From: Laura Gibbons
Sent: 04 April 2019 11:03
To: Planning.Responses
Cc: Andrew Wood
Subject: RE: Planning Consultation on: F/9/19/PL

Engineers Comments Regarding Flood Risk and Surface Water Drainage

APPLICATION F/9/19/PL

Description of Works: Change the use of 1/2 the site area to a hard standing storage area

Block Plan shows area bounded by: 500225.07, 104198.15 500277.07, 104250.15 (at a scale of 1:200), OSGridRef: TQ 25 422. The representation of a road, track or path is no evidence of a right of way. The representation of features as lines is no evidence of a property boundary.

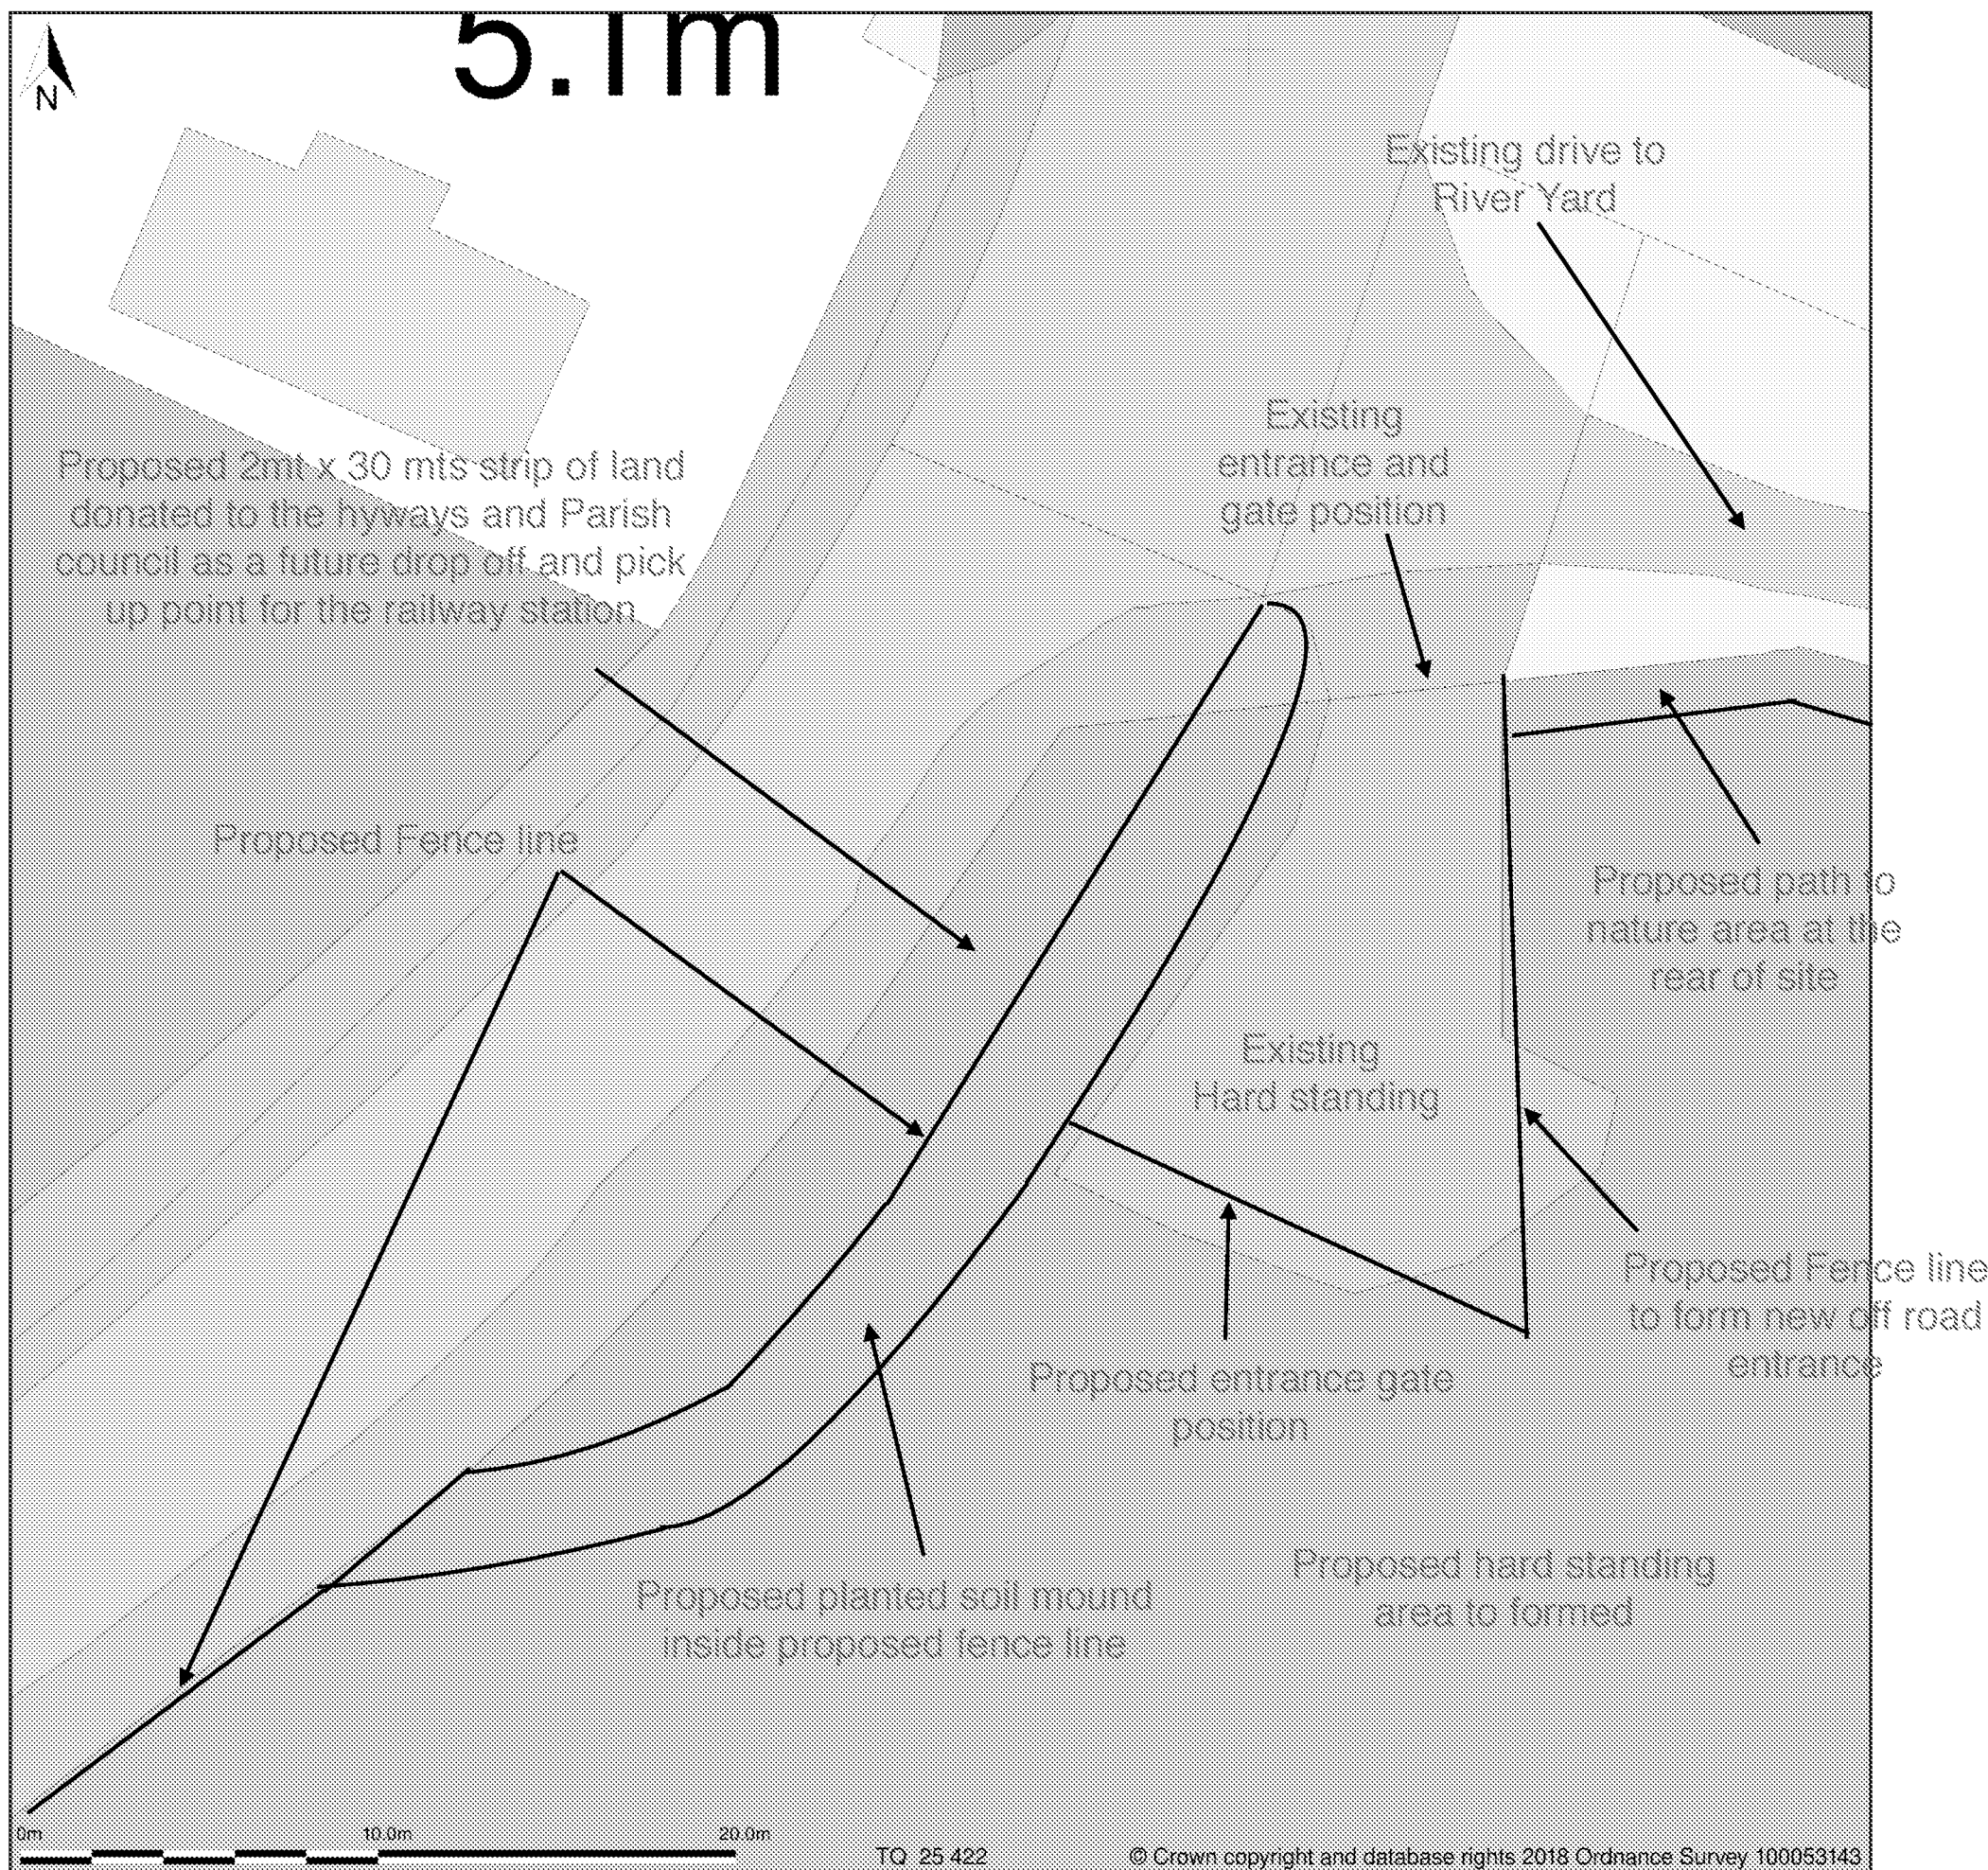
The hard surfacing is proposed to be permeable, yet no details as to its construction are included. The plans also show that a new drainage channel is proposed to connect into the existing ordinary watercourse. Land drainage consent would be required for this.

"Development shall not commence, other than works of site survey and investigation, until full details of the proposed surface water drainage scheme have been submitted to and approved in writing by the Local Planning Authority. The design should follow the hierarchy of preference for different types of surface water drainage disposal systems as set out in Approved Document H of the Building Regulations, and the recommendations of the SuDS Manual produced by CIRIA. Winter groundwater monitoring to establish highest annual ground water levels and winter Percolation testing to BRE 365, or similar approved, will be required to support the design of any Infiltration drainage. No building / No part of the extended building shall be occupied until the complete surface water drainage system serving the property has been implemented in accordance with the agreed details and the details so agreed shall be maintained in good working order in perpetuity."

"The development shall not proceed until details have been submitted to and approved in writing by the Local Planning Authority for any proposals: to discharge flows to watercourses; or for the culverting, diversion, infilling or obstruction of any watercourse on or adjacent to the site. Any discharge to a watercourse must be at a rate no greater than the pre-development run-off values. No construction is permitted, which will restrict current and future land owners from undertaking their riparian maintenance responsibilities in respect to any watercourse or culvert on or adjacent to the site."

Proposed Fence ans earth monud elevation

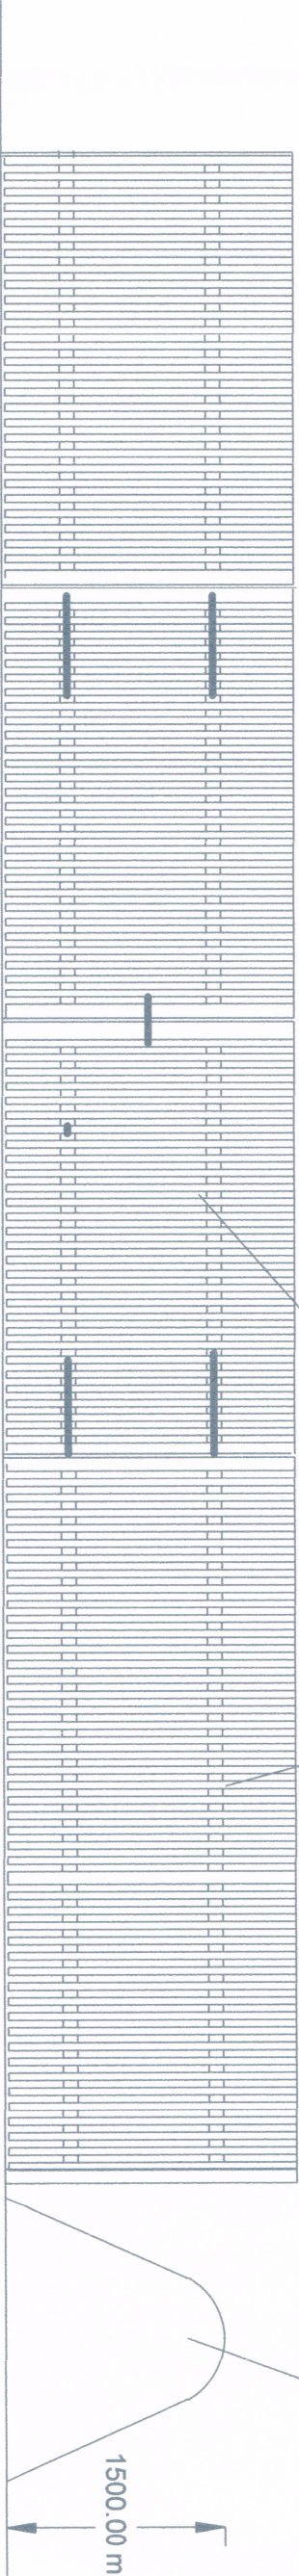
The application is within flood zone 3. The Environment Agency should be consulted. The proposals include two planted mounds. One of these is proposed to be 1.5m in elevation, this in my opinion is not suitable as it will displace flood water and alter flood flow paths. Ground levels shouldn't be increased on the site, I would therefore suggest a condition regarding site levels is imposed.
